From: Thomas Callaway
Sent: 15 January 2015 11:45
To: Planning.Responses
Subject: RE: Planning Consultation on: Y/101/14/HH

APPLICATION NO: Y/101/14/HH

Site Address: Kingsdene Yapton Road Barnham PO22 0BJ

Description of Works: Single storey side extension, two storey front extension & new bay window (resubmission following Y/49/14/HH)

Proposed Roof Plan

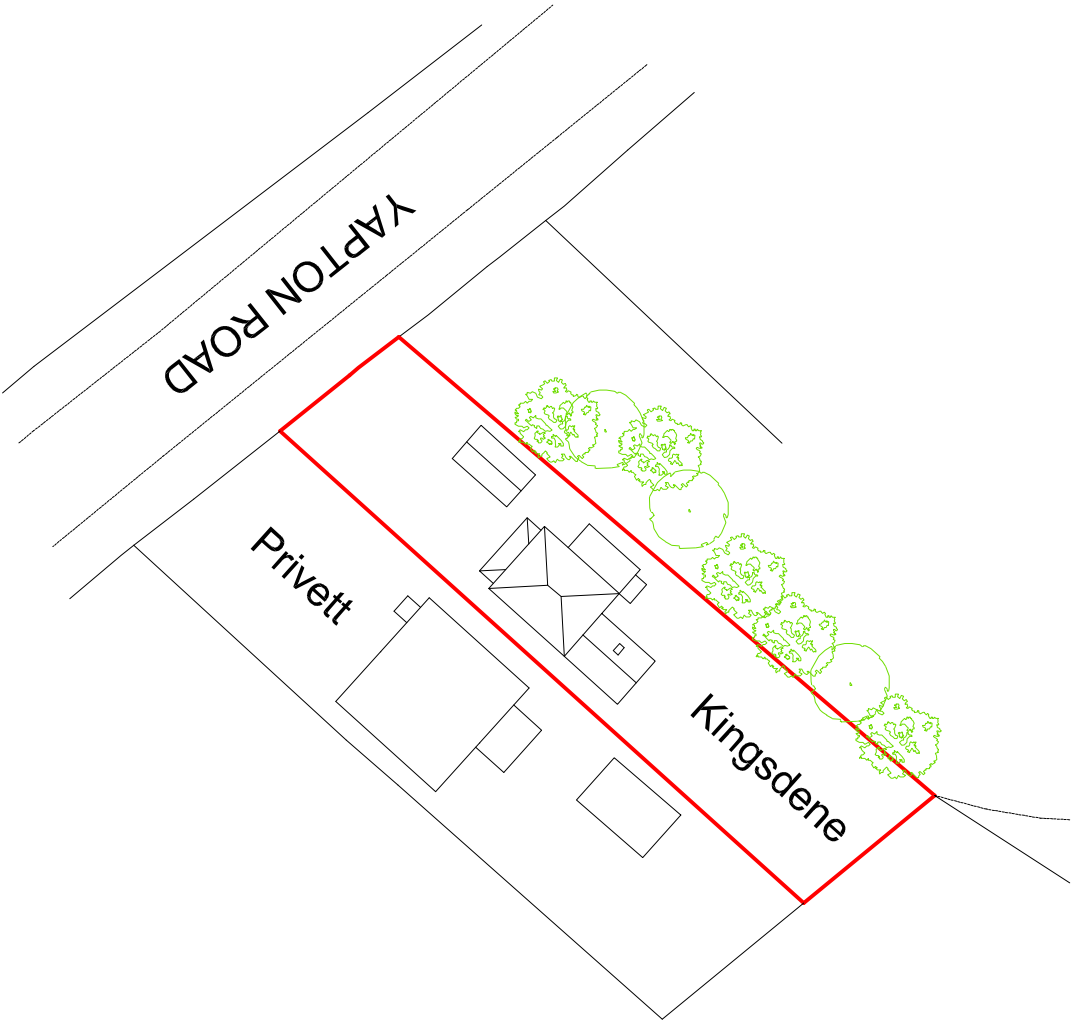
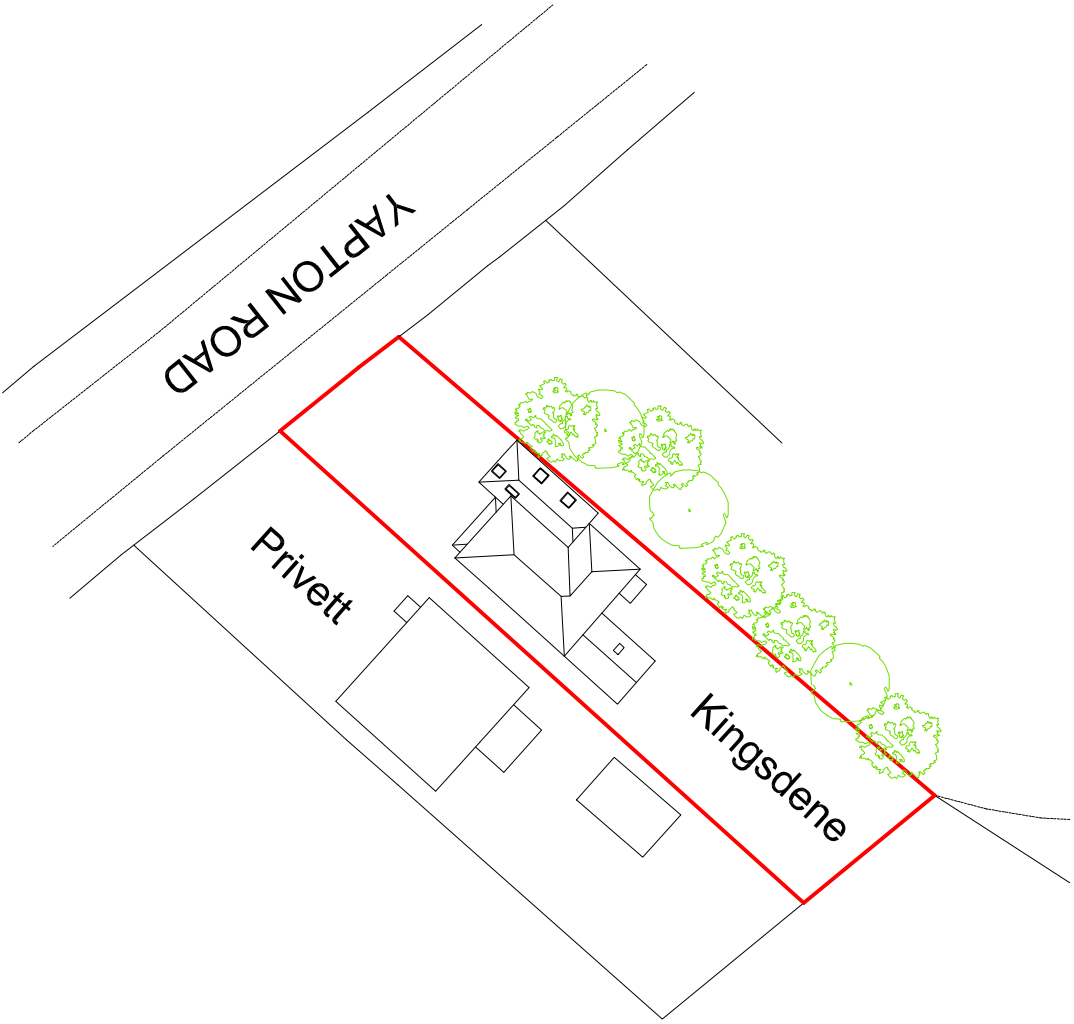
Infiltration must be investigated for surface water disposal from additional roof area.

Infiltration rates for soakage structures are to be based on percolation tests undertaken in the winter period and at the location and depth of the proposed structures. The percolation tests must be carried out in accordance with BRE 365, CIRIA R156 or a similar approved method and cater for the 1 in 10 year storm between the invert of the entry pipe to the soakaway, and the base of the structure. It must also have the provision to ensure that there is capacity in the system to contain below ground level the 1 in 100 year storm event plus 30% on stored volumes, as an allowance for climate change. Adequate freeboard must be provided between the base of the soakaway structure and the highest recorded annual groundwater level identified in that location.

Any SuDS or soakaway design must include adequate groundwater monitoring data to determine the highest winter groundwater table in support of the design. The applicant is advised to discuss the extent of groundwater monitoring with the Council's Engineers. Supplementary guidance notes are also enclosed for information.
